Our reference: EF13/5467
Contact: Brad Tanswell, 02 68 835 330

I refer to the Project Application, Environmental Assessment (EA) and accompanying information provided for the proposed Dubbo Zirconia Project (ref SSD 5221) received by the Environment Protection Authority (EPA) on 18 September 2013.

ATTACHMENT A

Assessment of the Proposal and Request for Additional Information

Figure 6: Liquid Residue Storage

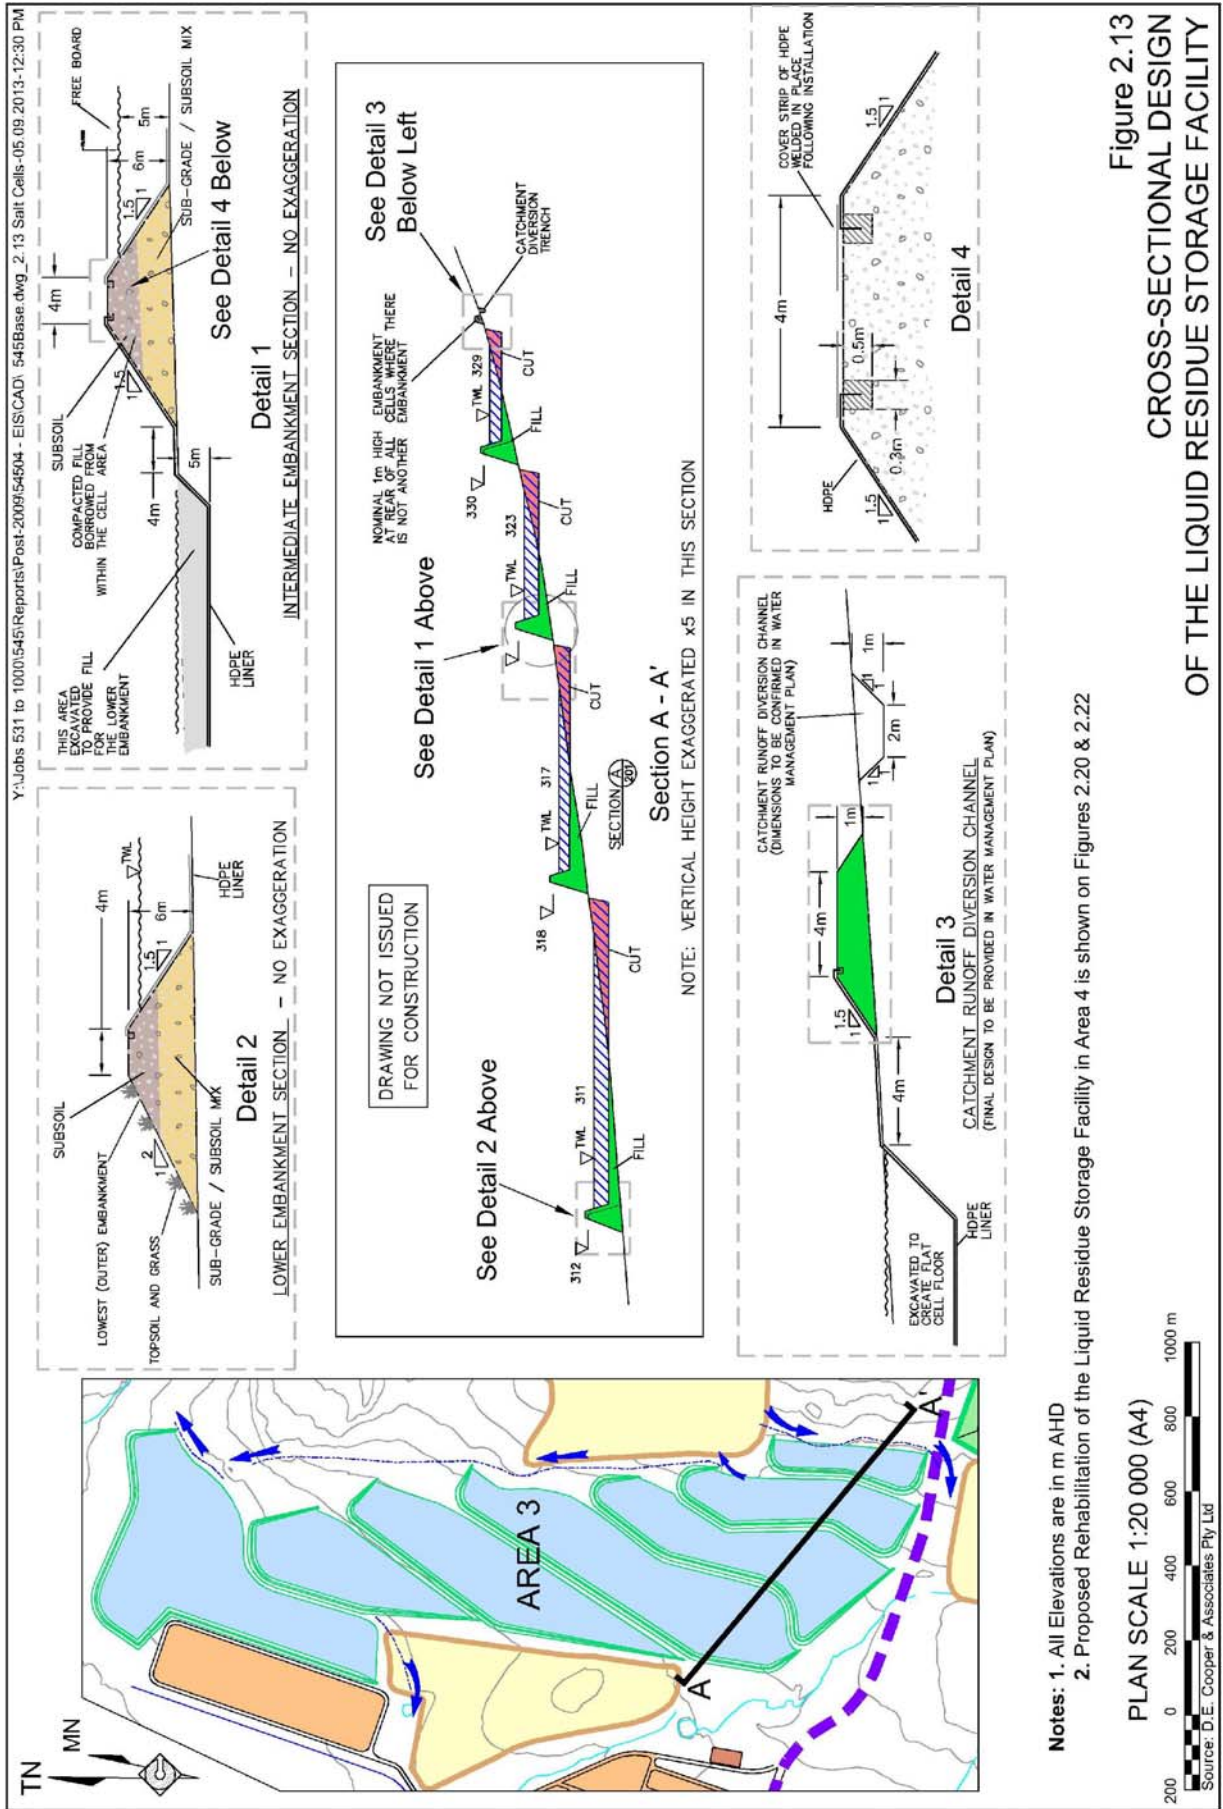
Siting of the liquid residue storage facility

The specialist groundwater reported indicated further assessment was needed on the footprint of the LRSF to assess whether siting of the facility could avoid areas of alluvial sands or basalt (due to potential high fracture permeability of igneous rocks, where that are present, groundwater flow rates can be greater than 200m/year).

Prior to construction of the LRSF, further assessment should be conducted on the footprint of the LRSF to assess whether siting of the facility could avoid areas of alluvial sands or basalt.
